DECISION DELEGATED TO HEAD OF PLANNING

Application No: H14-0224-24 **Applicant:** Cecil Francis Ltd

Proposal: Details of surface water disposal, external materials, external doors/door frames, window frames and gas/electricity boxes (Conditions 9, 14, 15, 16 and 19 of H14-0706-22)

Location: Cecil Francis Ltd Bear Lane Pinchbeck

**Plots 1 & 3
Elevations as Proposed.**

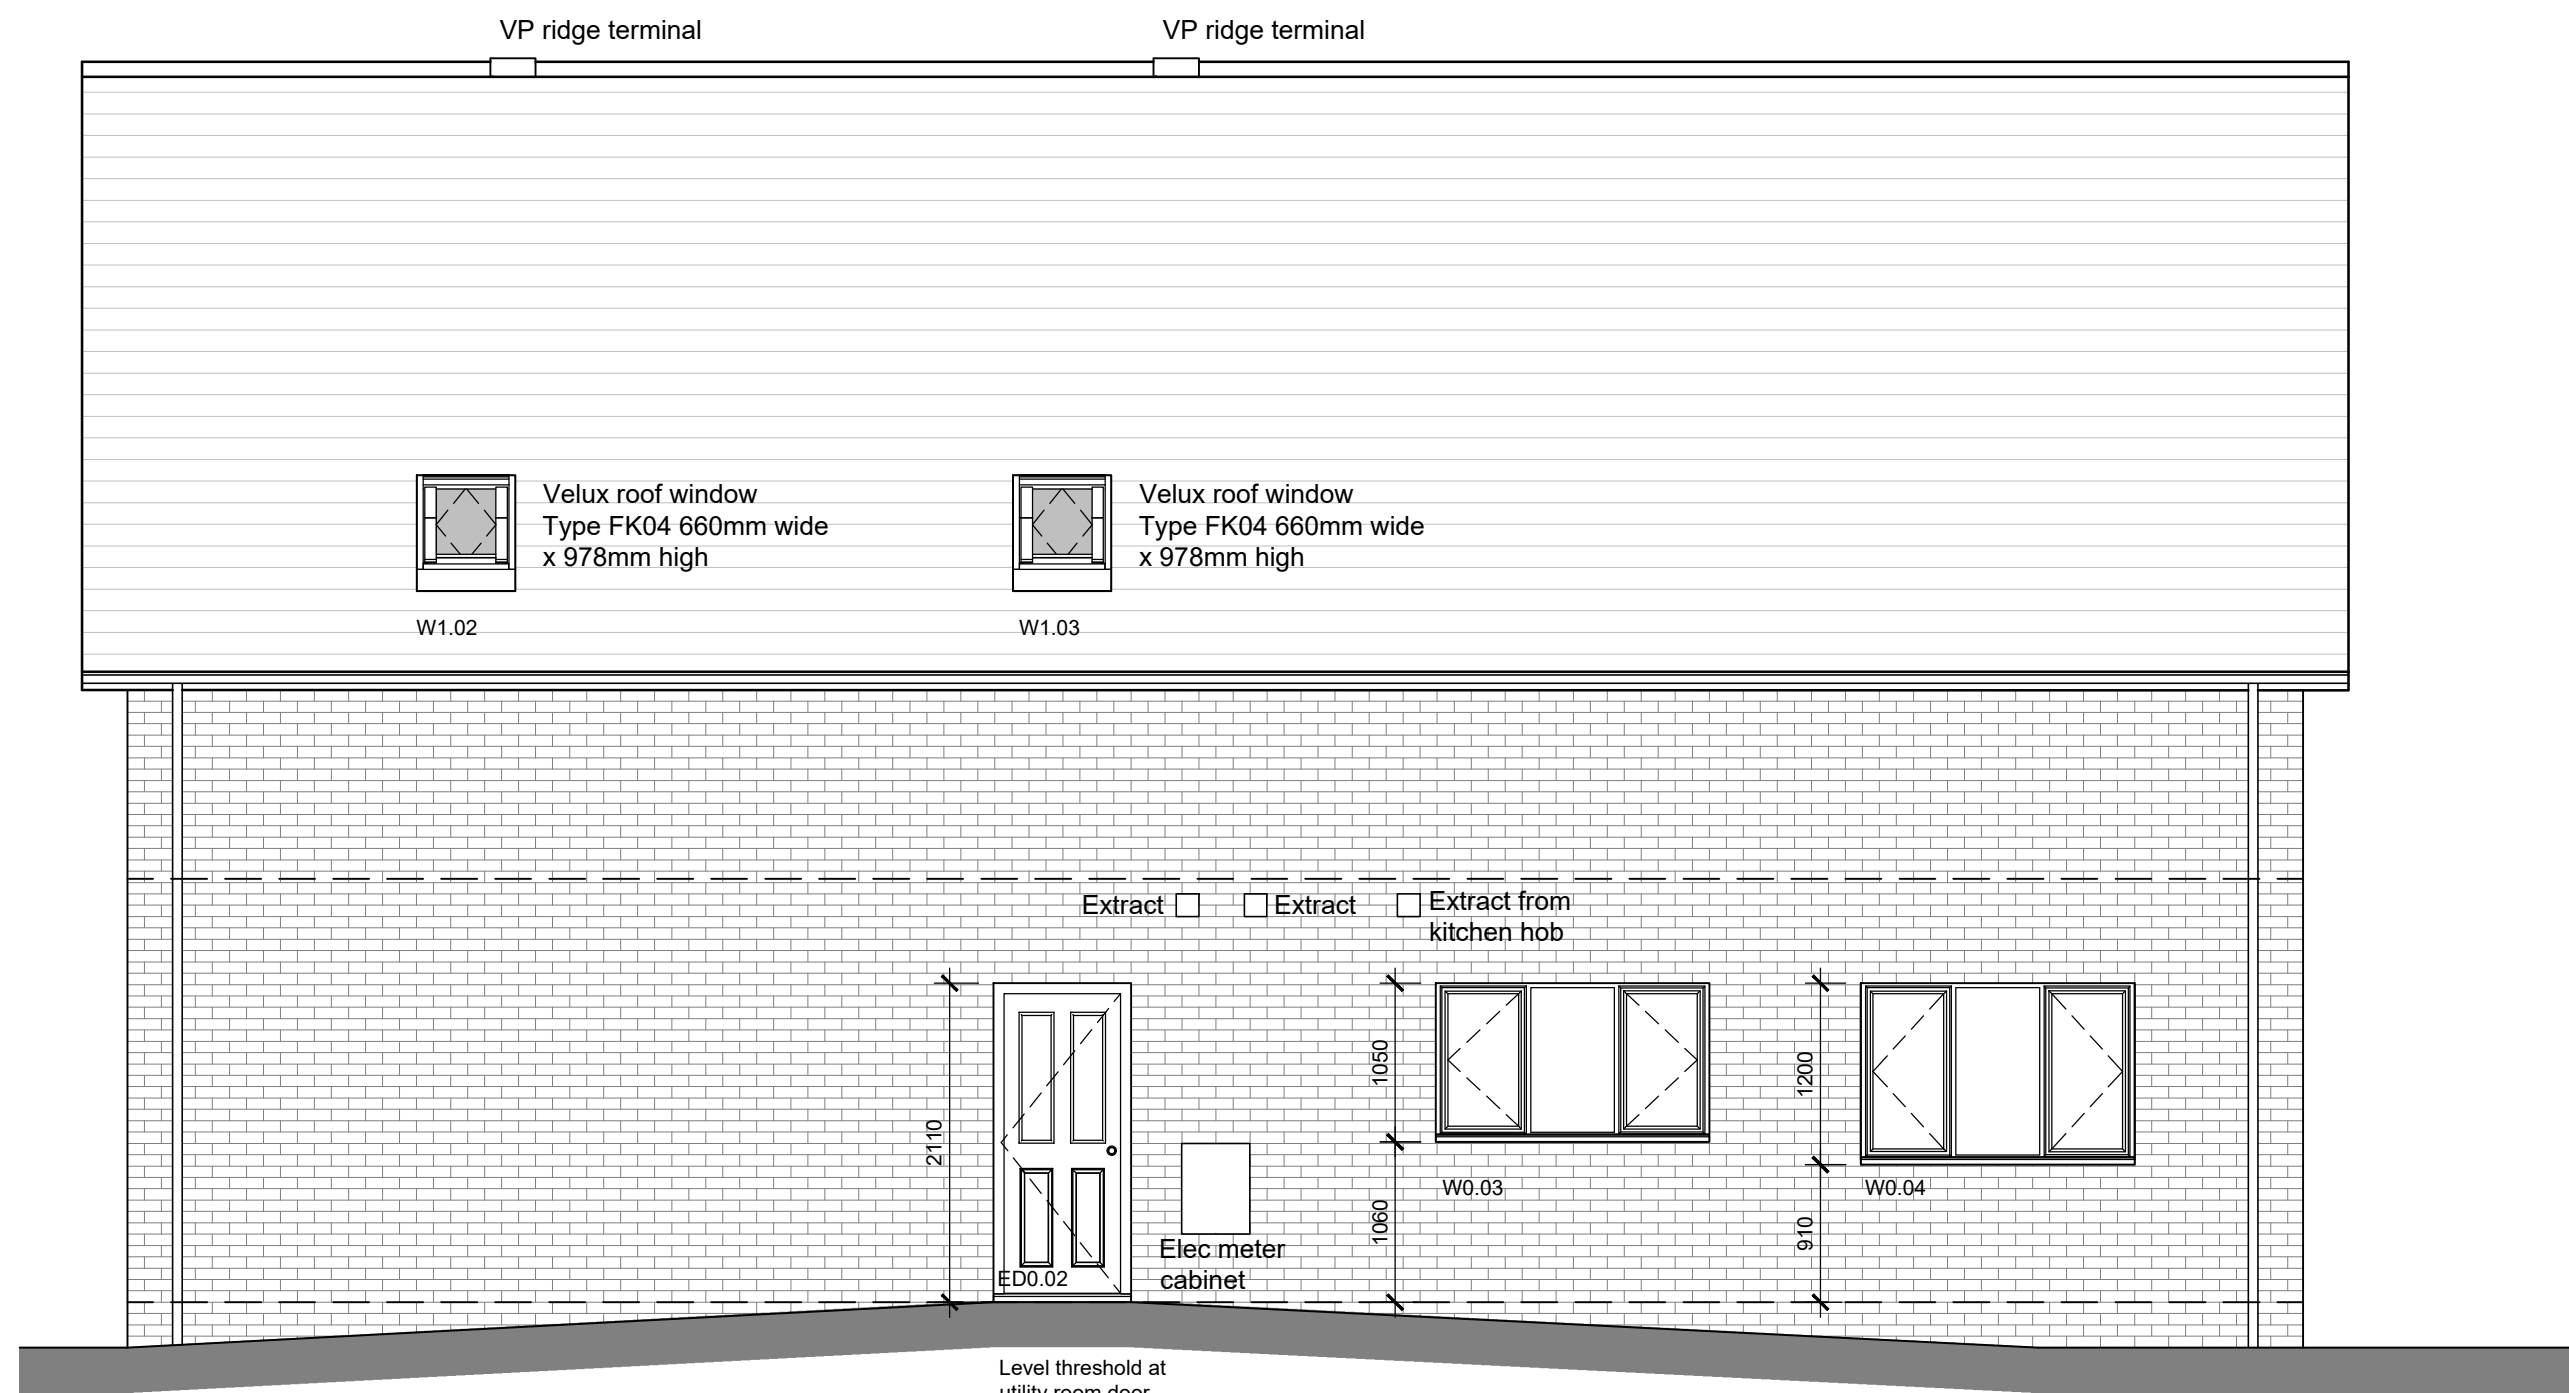
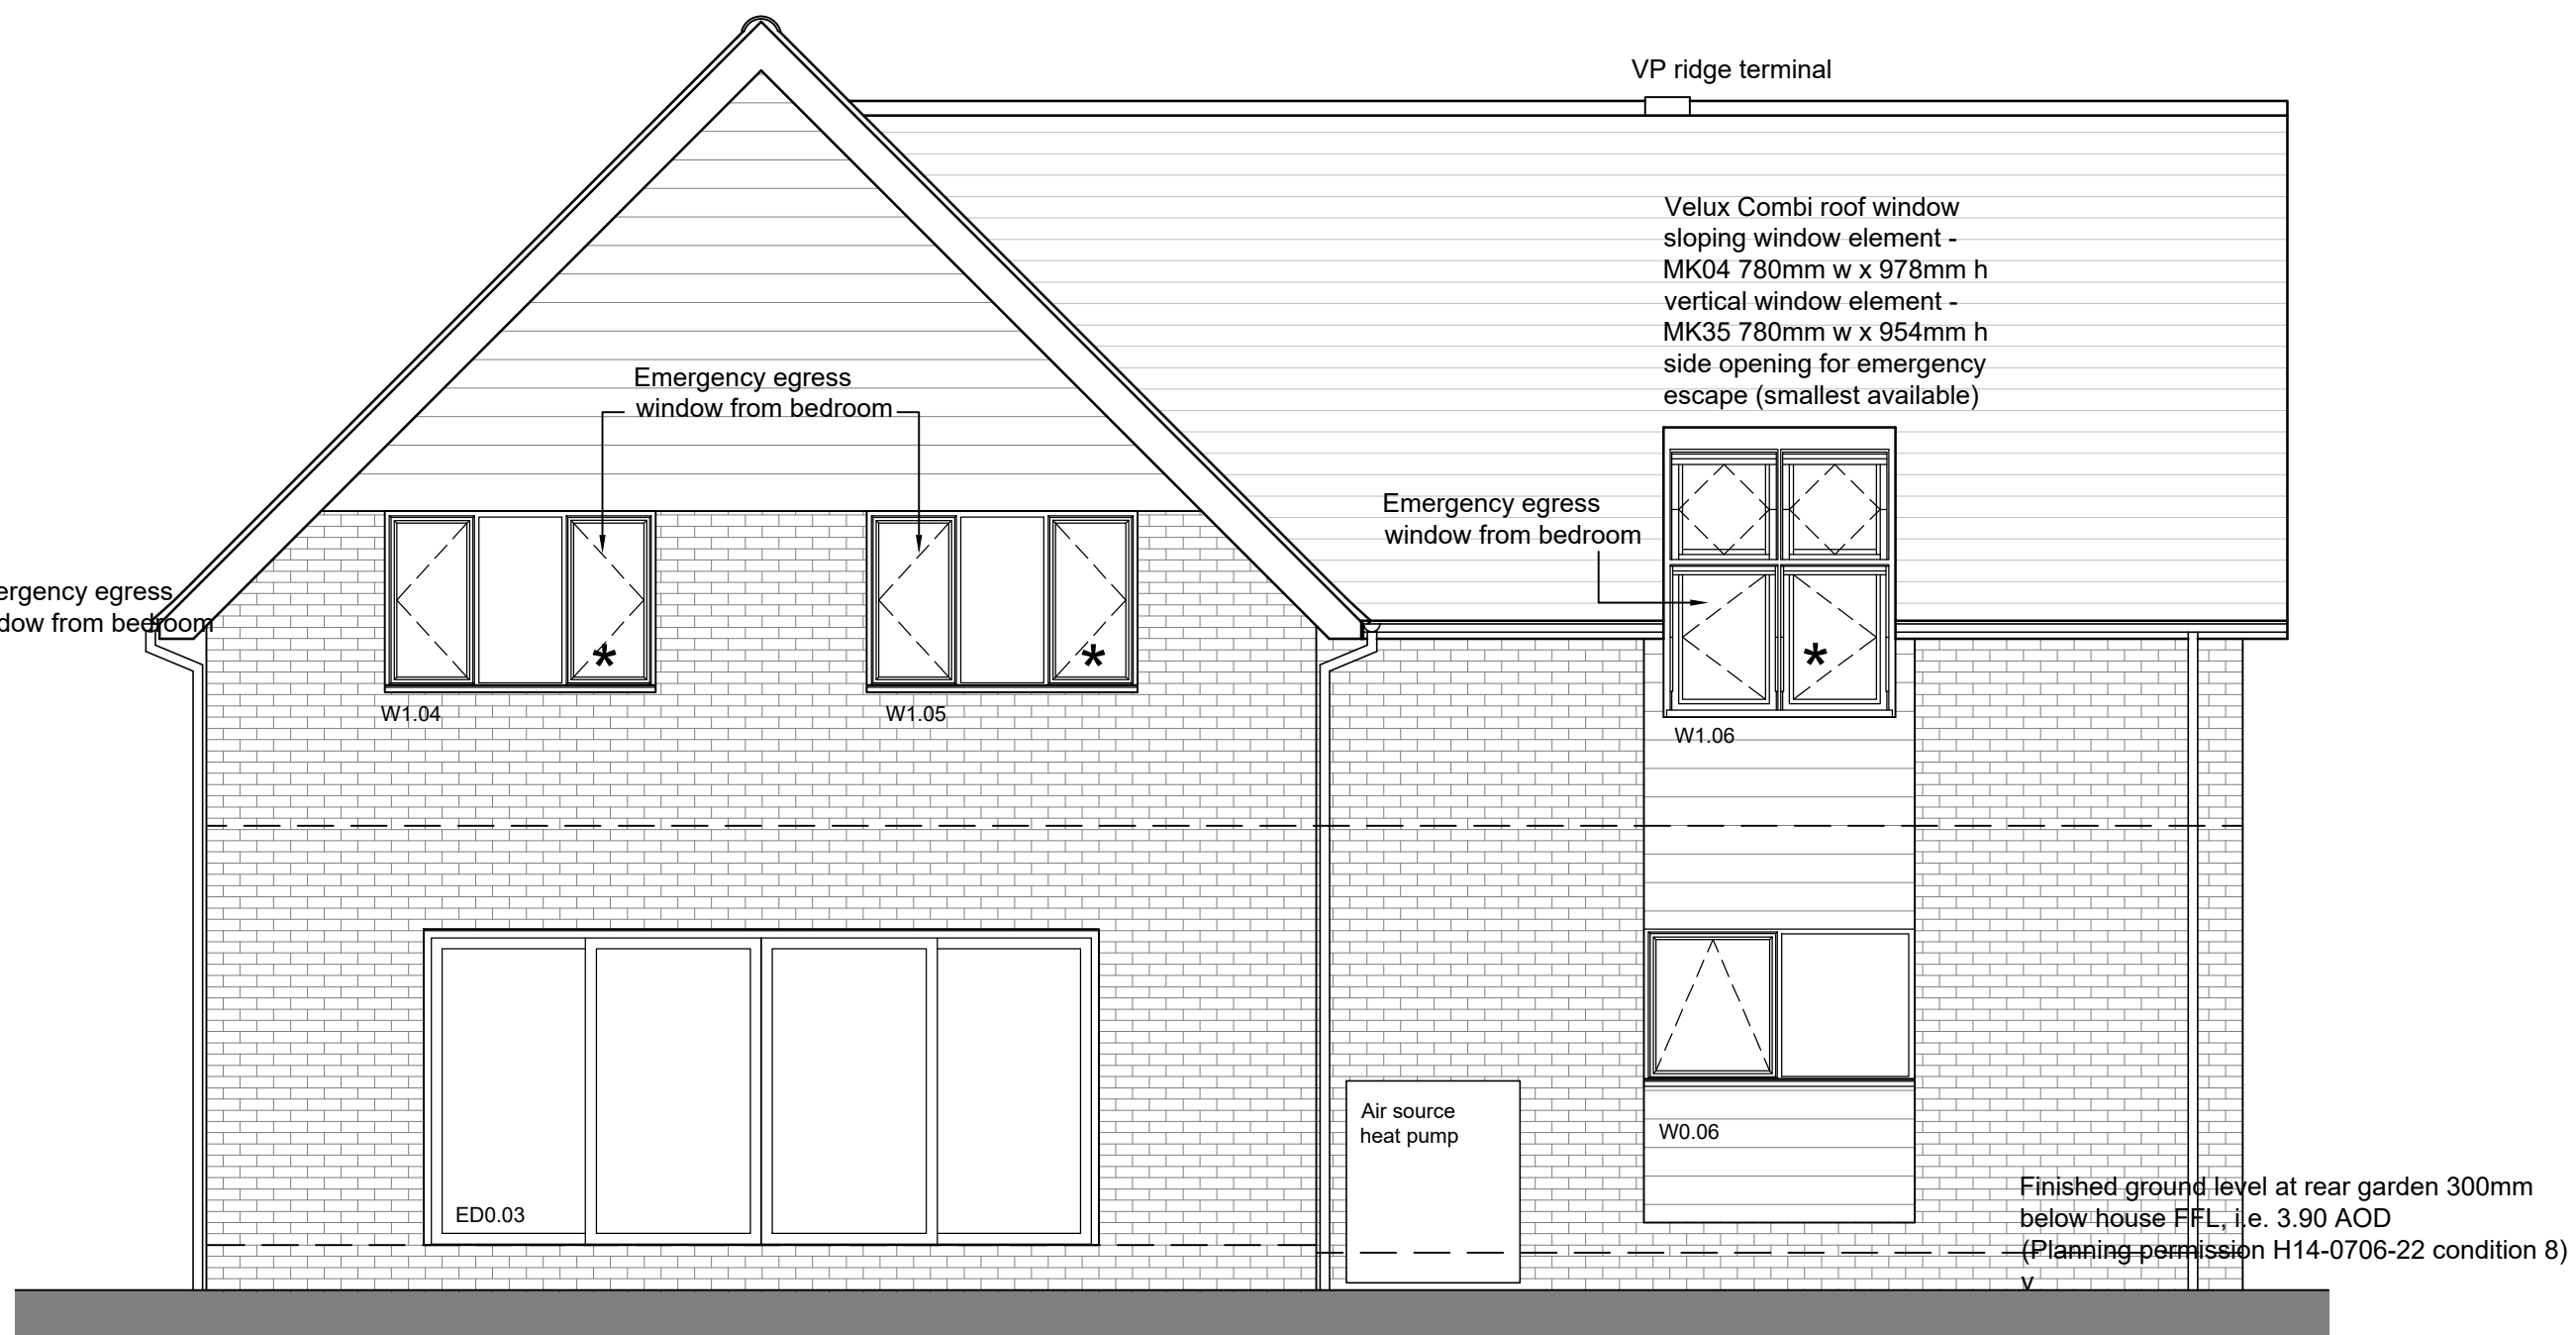
Plots 1 and 3 show on the north east elevation two velux roof windows, two casement windows at ground floor level, and an upper emergency access window at first floor.

For Plots 1 and 3 the electrical cabinet is shown on the north west elevation. It is a standard cabinet in white. The air source heat pump is shown on the south west elevation in the centre of the site away from neighbours on the rear elevation. It only comes in a standard grey colour and is an Ecodan R32 Air Source Heat pump.

It is considered that the details are satisfactory and condition 16 can be discharged.
